Mountain View Electric Association, Inc. (MVEA) has these comments about the following:

Project Name: Mountain's Edge Subdivision

Project Number: SF 1826

Description: Approval is being requested for the Final Plat of Mountain's Edge Subdivision for five (5) residential lots on approximately 40 acres. This parcel is located northeast of McClelland Road and Scott Road in Section 13, Township 12 South, Range 63 West and is currently zoned RR-5 (Residential Rural).

FINAL PLAT
MOUNTAIN'S EDGE

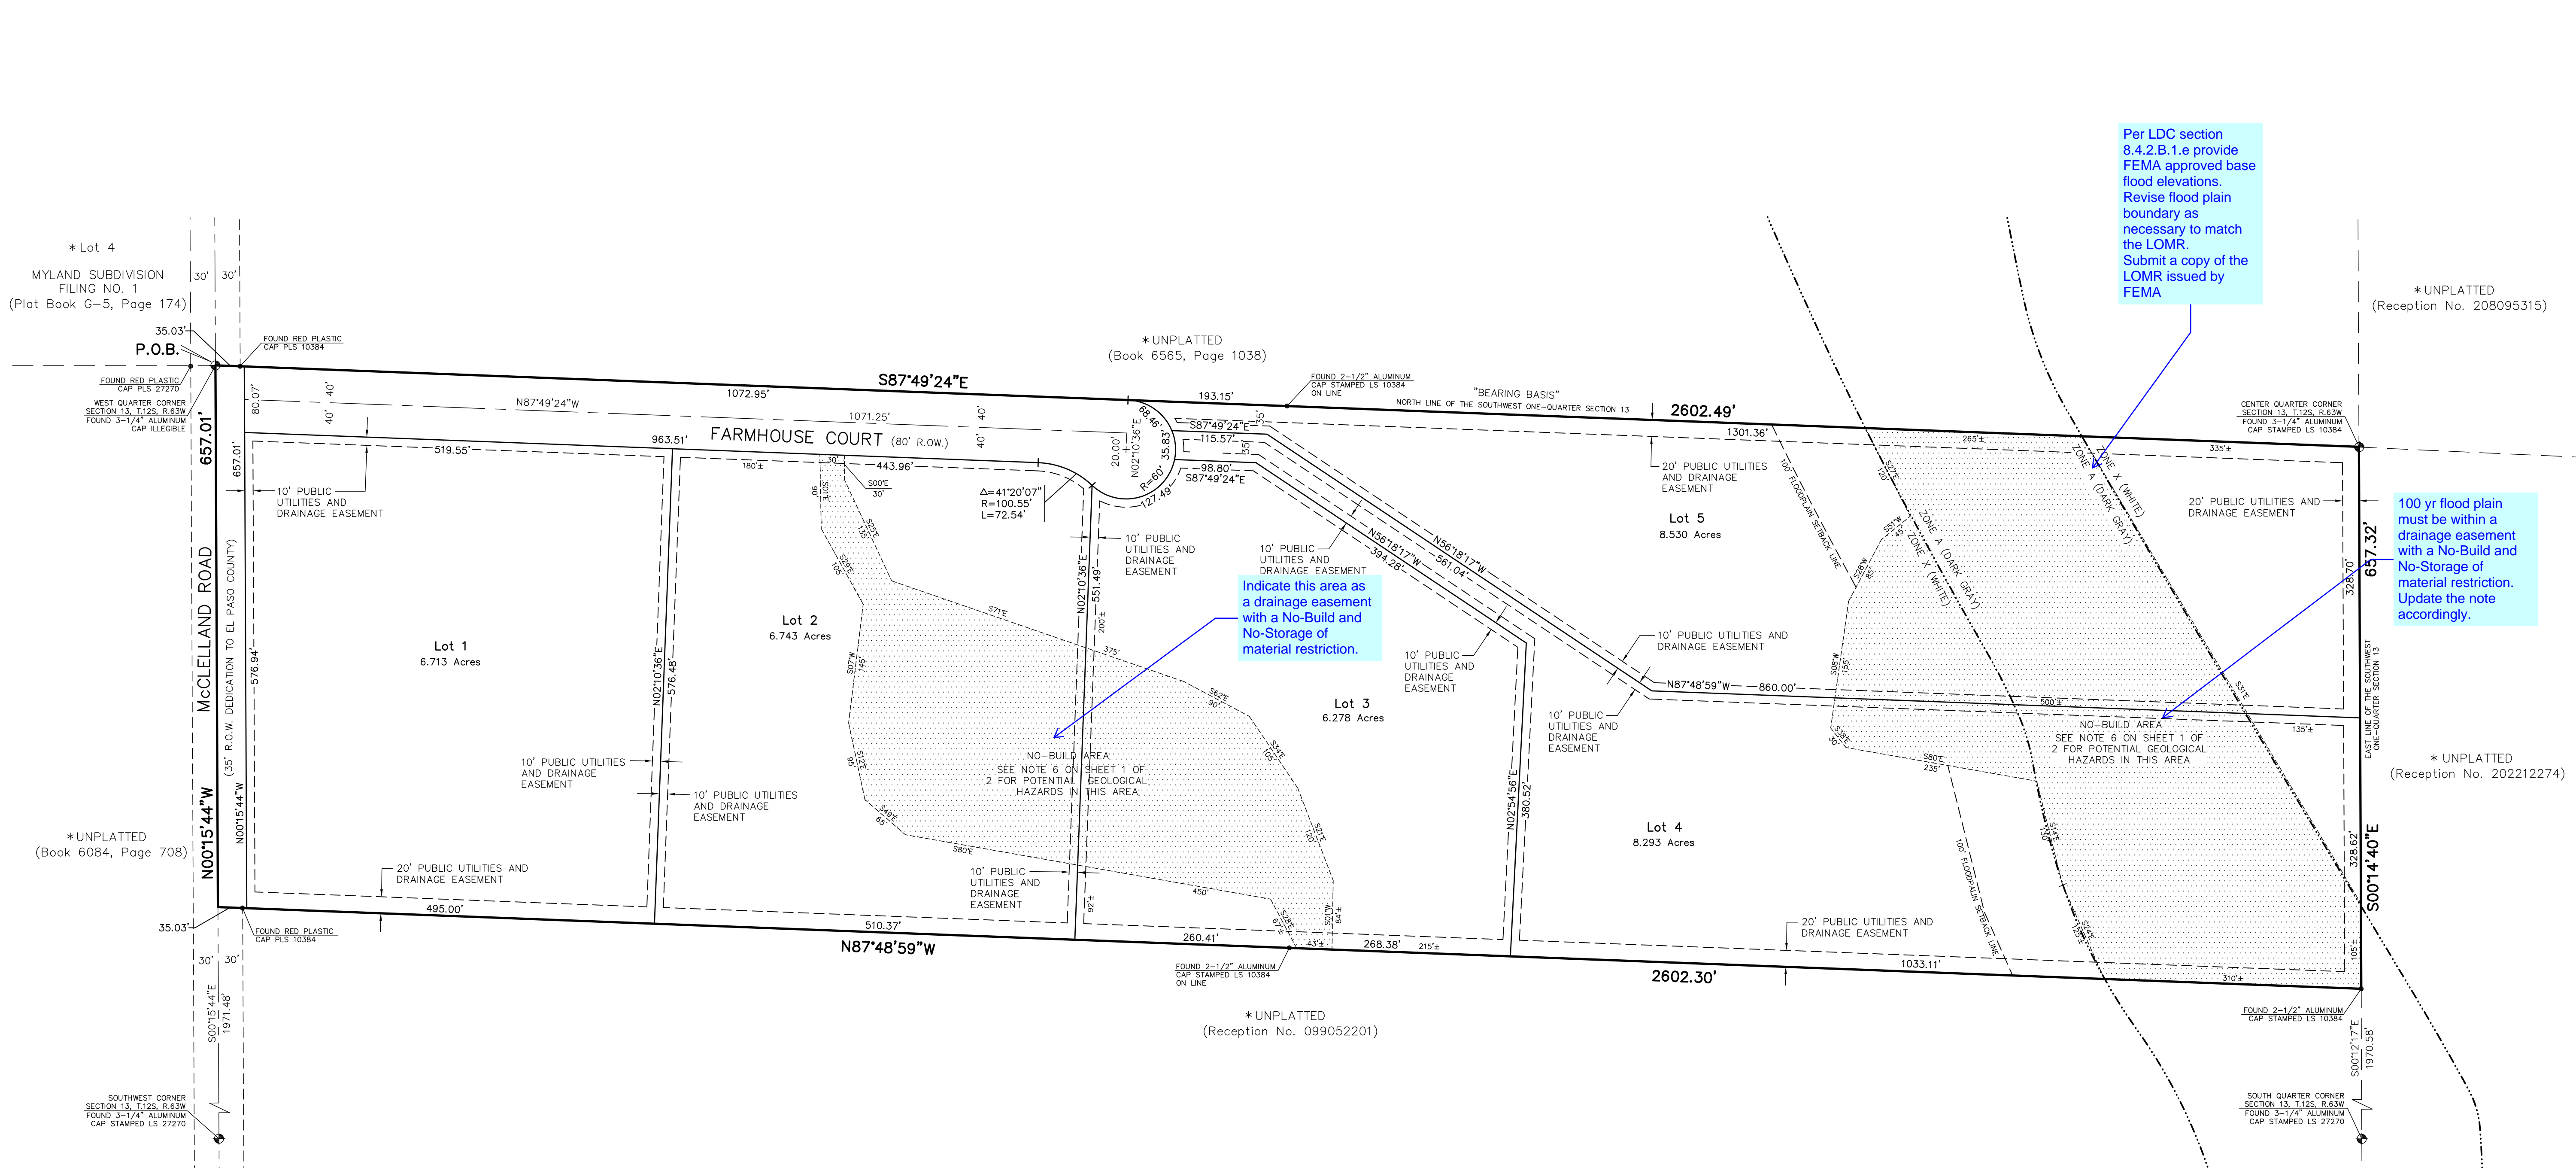
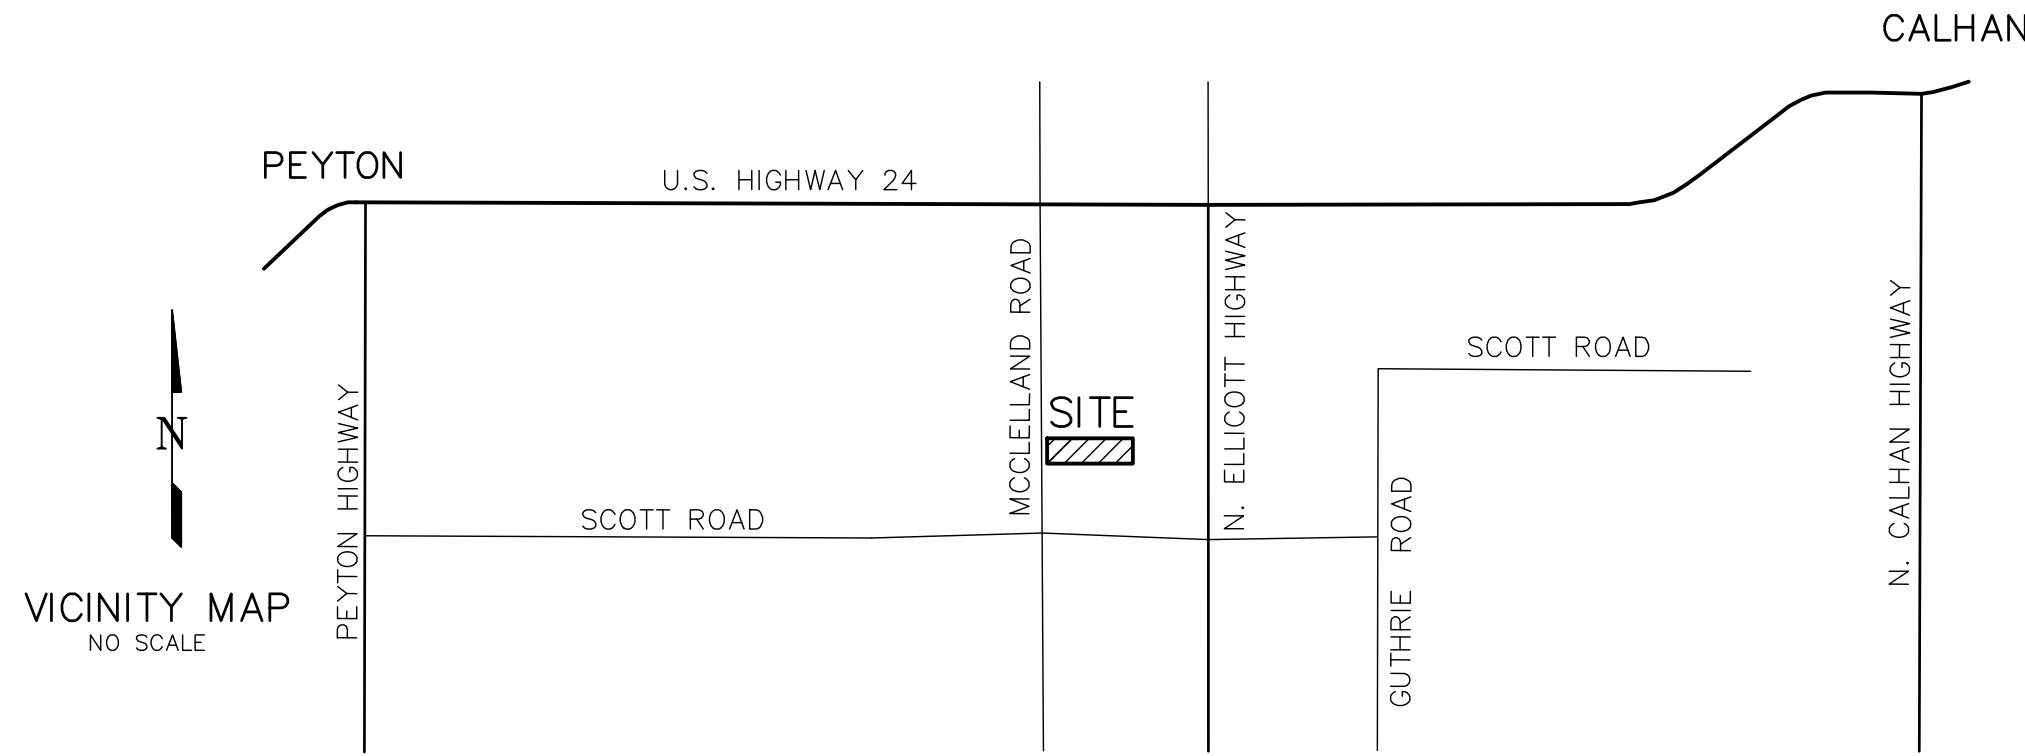
MVEA notes the utility easements shown on the final plat of ten (10) foot front, side and back lot lines along with a twenty (20) foot exterior subdivision easement. MVEA also requests platting of existing MVEA facilities with easement on the plat. Additional easements may be required once a review of civil drawings with grading and erosion plan is provided to MVEA in order to serve this subdivision.
